**Comments appertaining to  
ESSO's Site Specific Plans  
for SCP**

**Application by ESSO Petroleum Company Ltd  
for an Order Granting Development  
Consent for the Southampton to London  
Pipeline Project**

**Application Reference EN070005**

## Southwood Country Park Site Specific Plan

Drawing title:
8.60 SOUTHWOOD COUNTRY PARK: CONSTRUCTION STAGE SHEET 3 OF 3

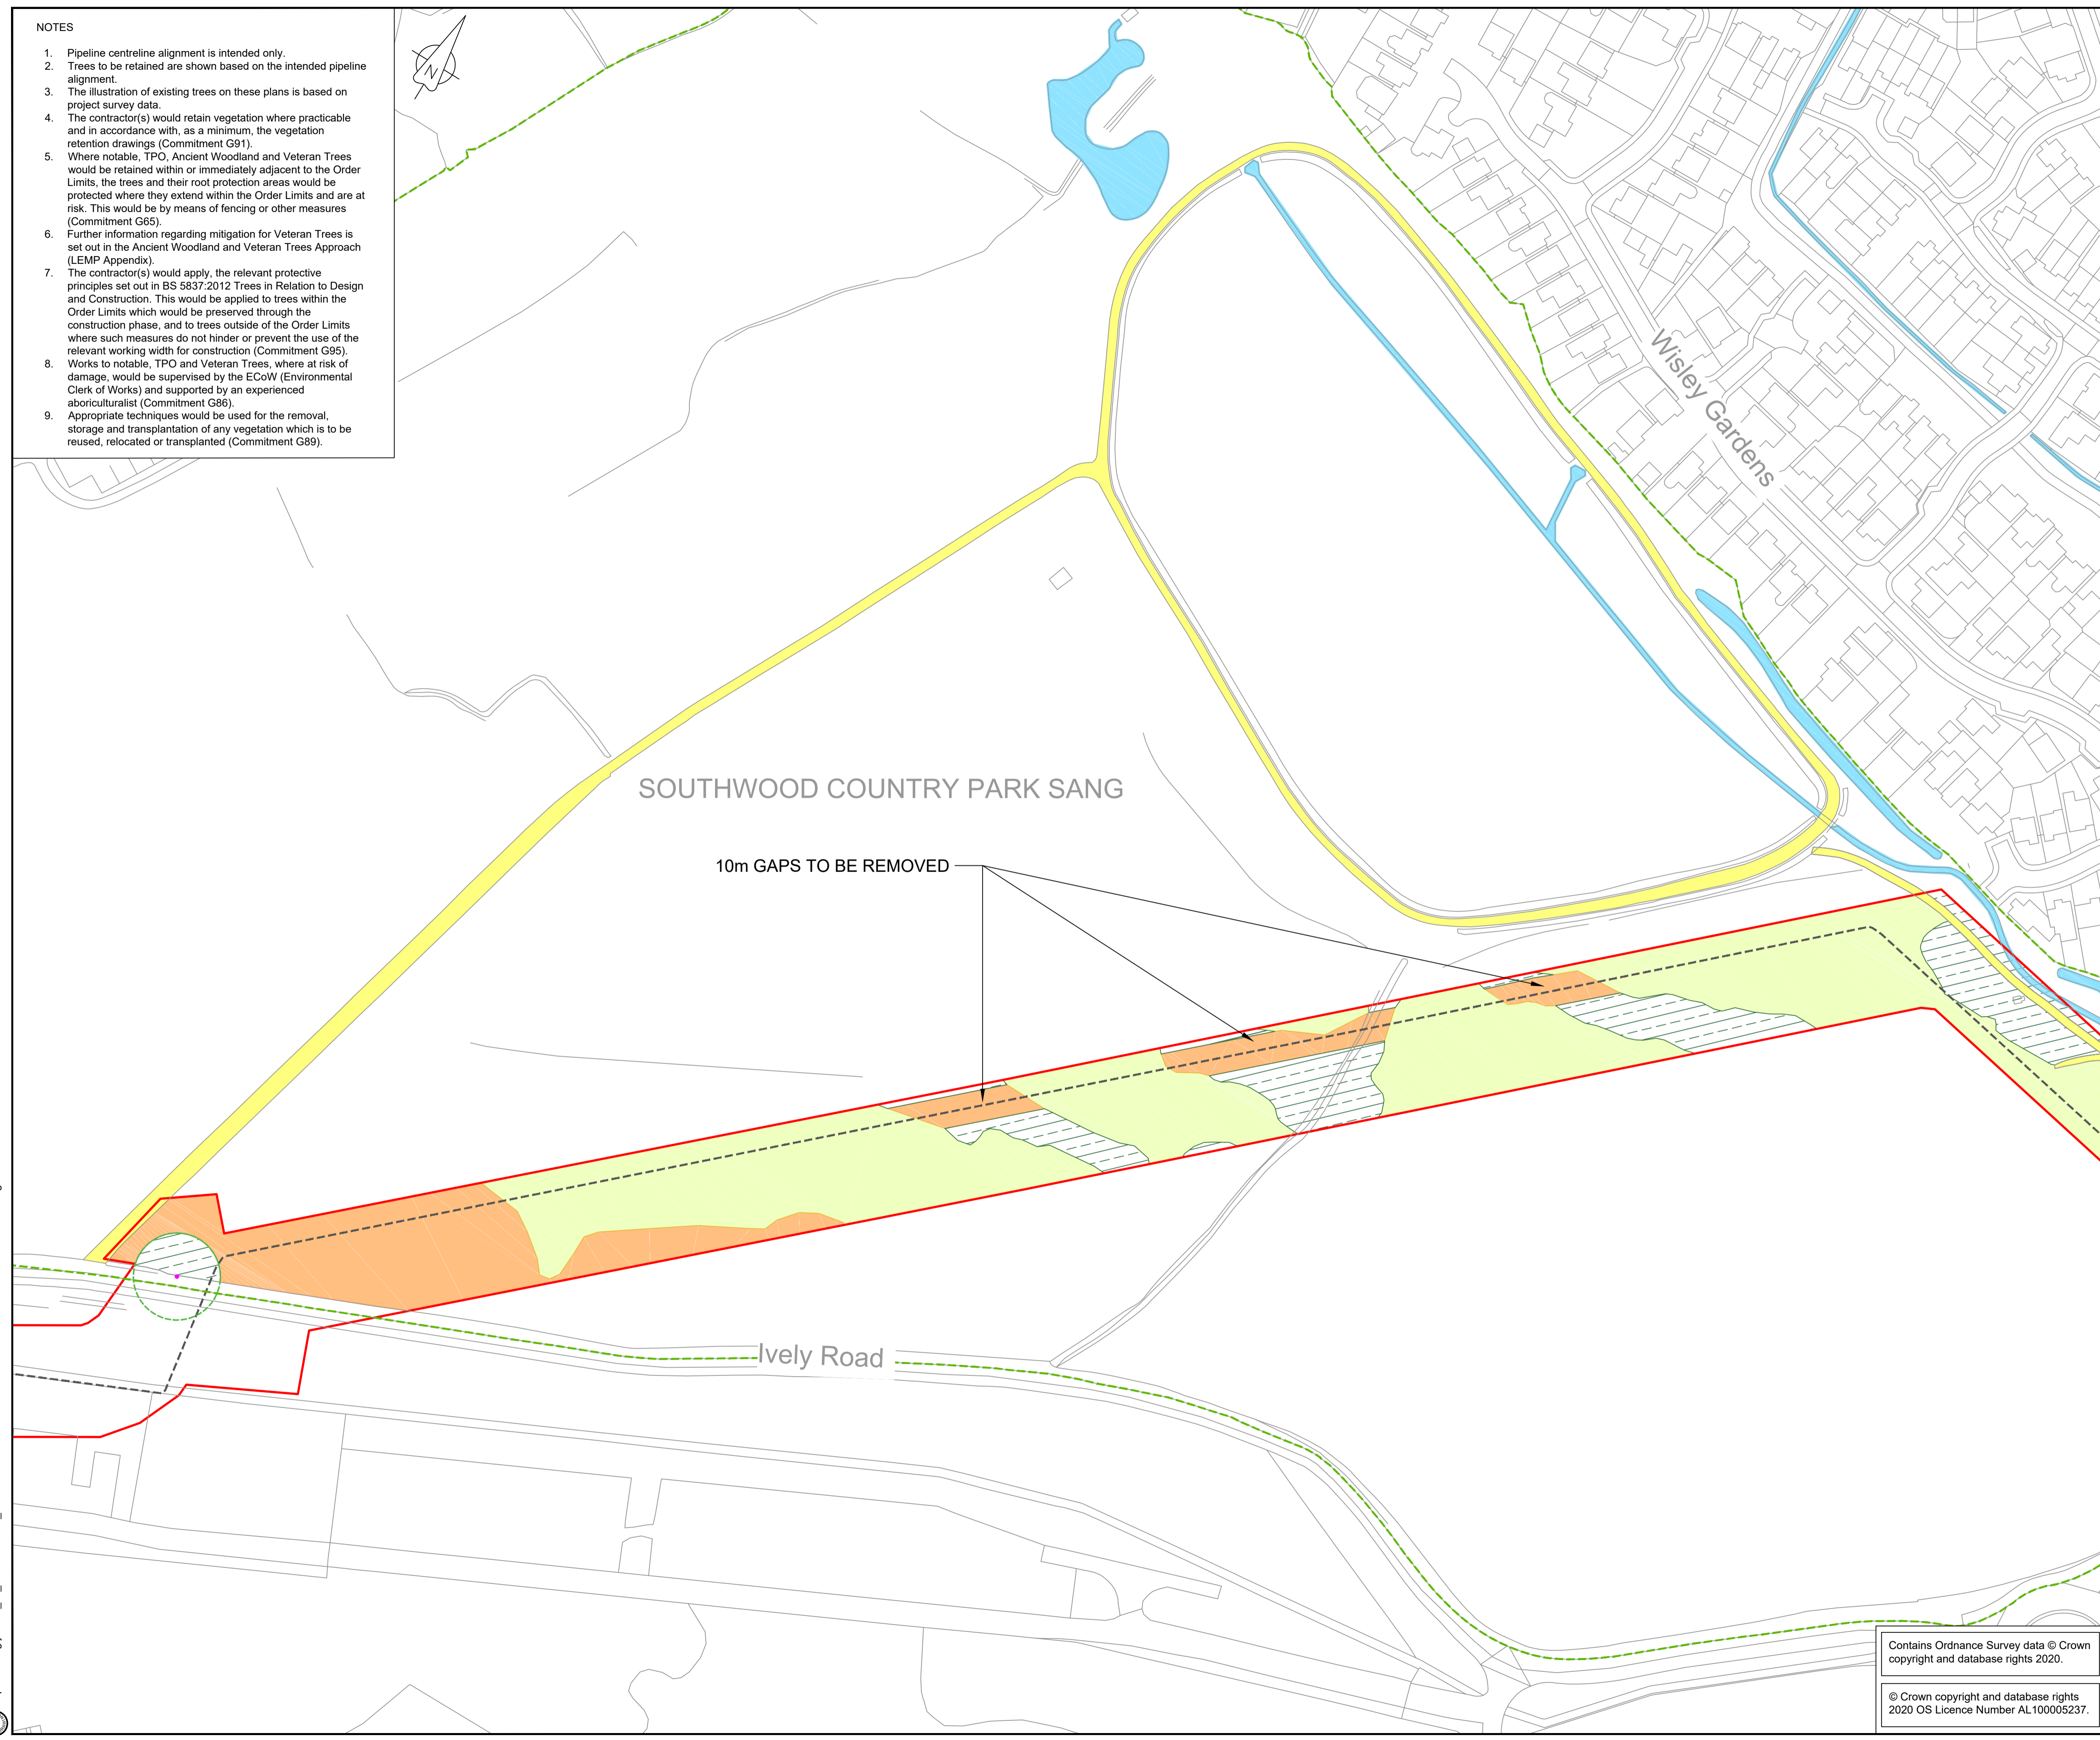
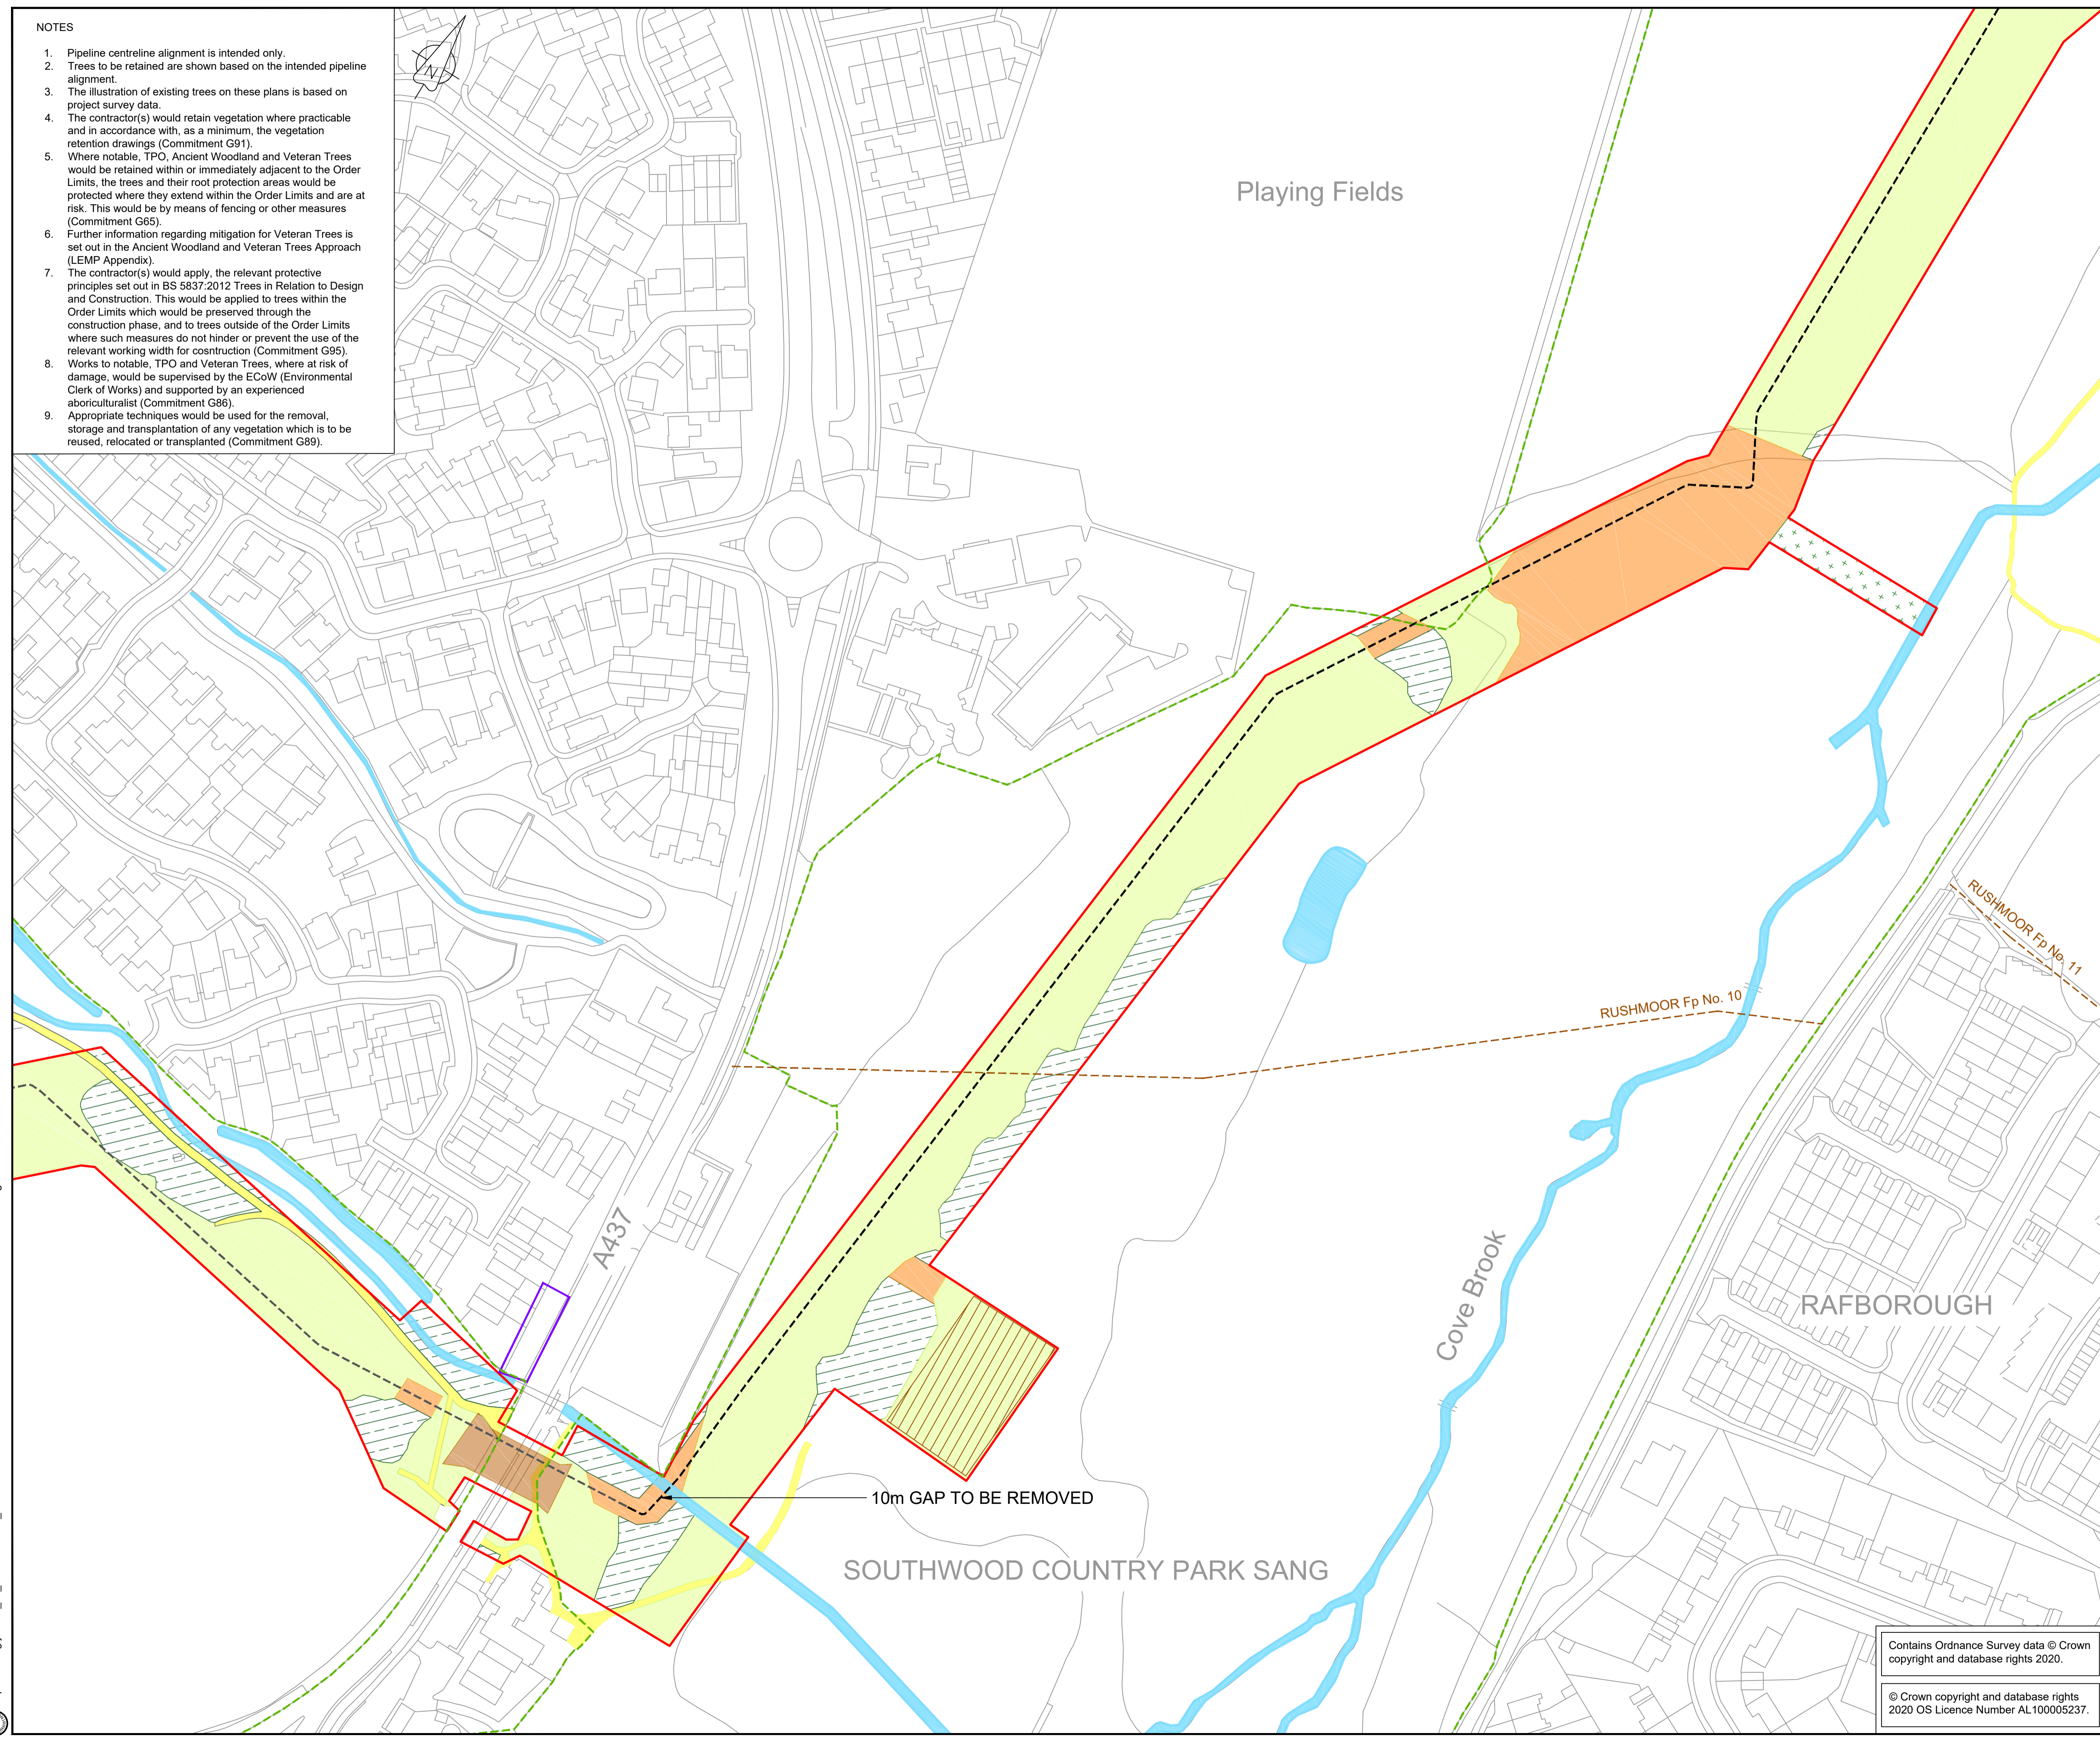
- 3.1.1 Within 3.1.4 there is mention of removal of 10m of a woodland belt. If this removal is essential for access then RBC would expect the tree loss to be mitigated on site, with mitigation negotiated after a biodiversity offsetting calculation or some other mechanism has been undertaken to assess the biodiversity loss.
- 3.1.2 Within discussions with the applicant they have not agreed to mitigate tree loss using offsetting but will only provide one to one compensation for mature tree felled. The council assume the mitigation will be in the form of whips and therefore tree loss on site is likely to lead to significant biodiversity loss. RBC is of the view that this is not adequate mitigation and would request that a mitigation package, including appropriate mitigation for tree loss within the Country Park be secured through a s106 agreement.

- 4.1.1 Again there appears to be significant tree loss to facilitate the auger bore this will require mitigation as above.

- 5.1.1 RBC recognises the sensitivity of the Dam and has therefore agreed this work can be done to the end of the bird nesting season. As this area is biodiverse the council would request that vegetation clearance is minimised in this area. Any clearance required would need to be mitigated. The council is discussing the creation of addition marsh habitat within Southwood Golf Course West SINC as part of the EIP, however it continues to be the council's view that any habitat mitigation should be secured as part of a s106 agreement and be linked to the planning process, rather than delivery as part of the EIP which is intended for enhancements.

- 6.1.1 This process will lead to the greatest damage to the Country Park with loss of hedgerow and grassland habitat. The council is particularly eager to ensure the acid grassland and marsh habitats are restored and mitigated within the project.
